Construction of 1No. 2 bedroom chalet bungalow
Land adj to 65B Gravits Lane Bognor Regis

Thank you for your internet representation made on 13th September 2014 which has been recorded as '**an objection**' with the comments as follows:

BLOCK / LOCATION PLAN
LAND ADJACENT TO 65B GRAVITS LANE BOGNOR

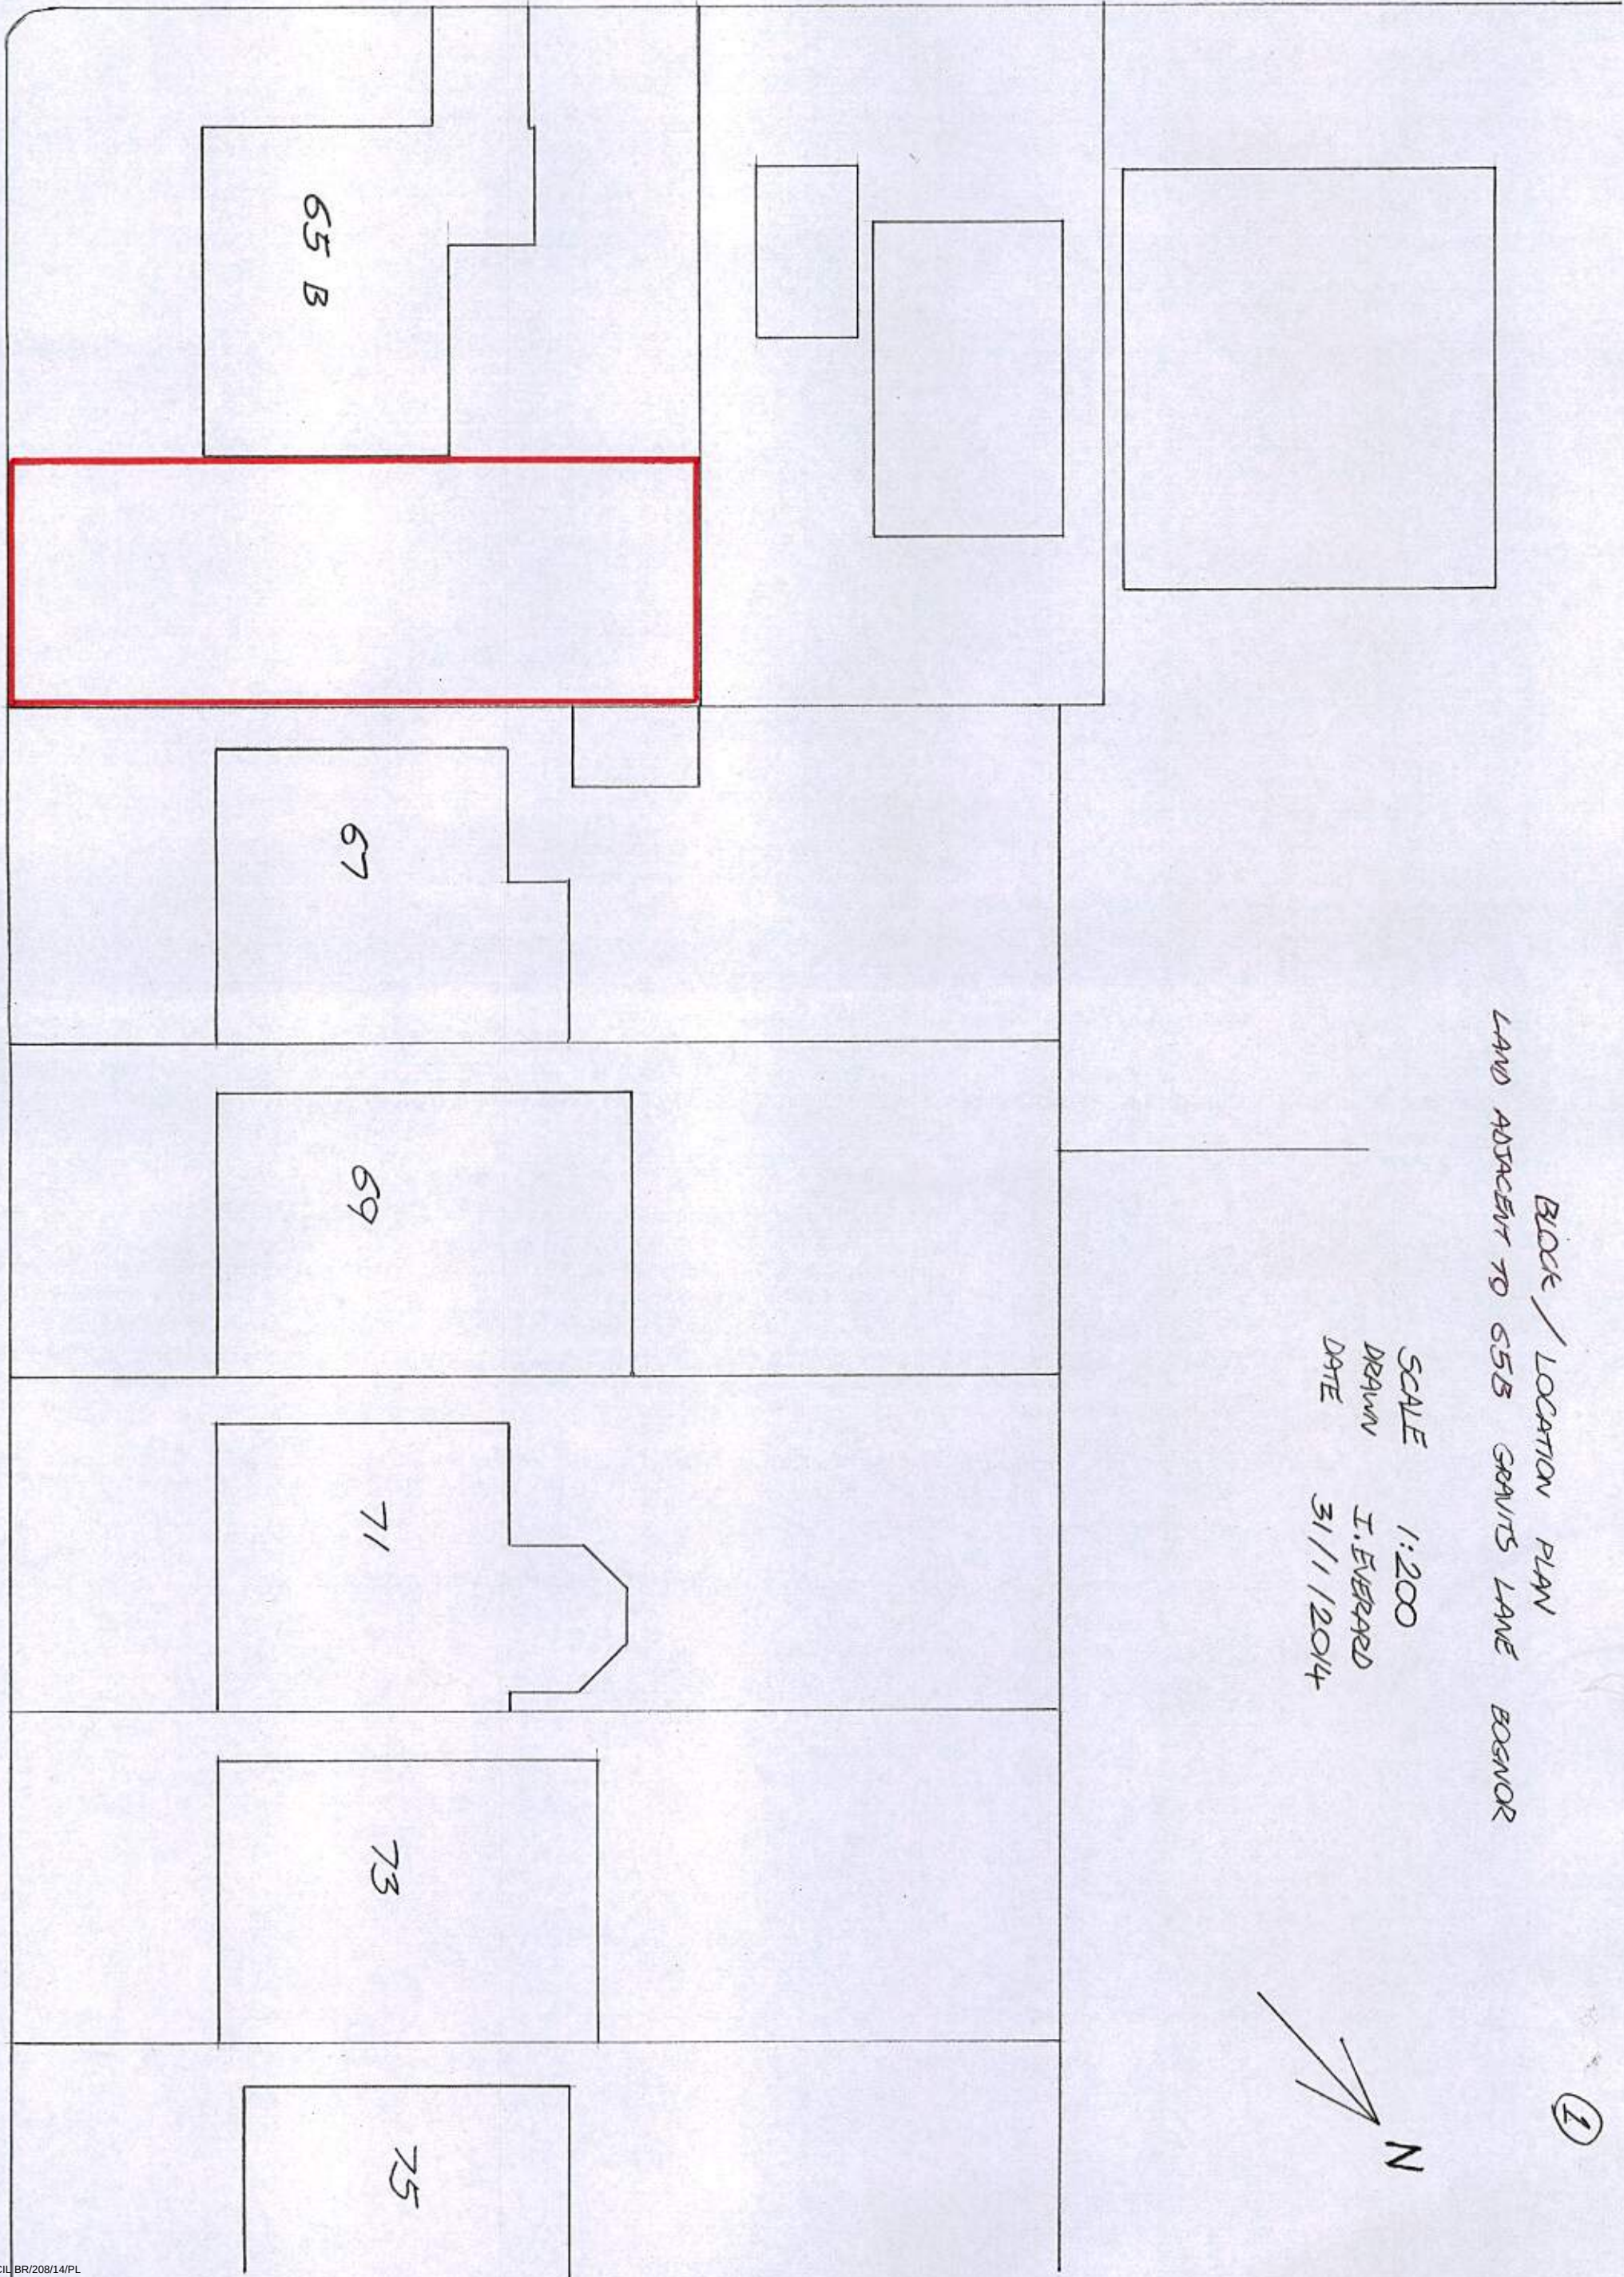
I feel that building a property in between these two properties ridiculous. The land is too small, have examine the site to see that the builder has already put footings in place and electric meter. Will not be enough parking spaces, will be opposite a water pump station which requires access at all times which if cars park outside new build will make it a dangerous situation. Piping system is old in street and adding further pipes to house will create further problems to the pumping station, to what we already have. Hazardous for more cars to be parked at top end of road, 65b will have new layout driveway and will impair vision for traffic cornering. This is a nightmare corner with blind spots either way and will make further parking in this area a hazard for traffic.
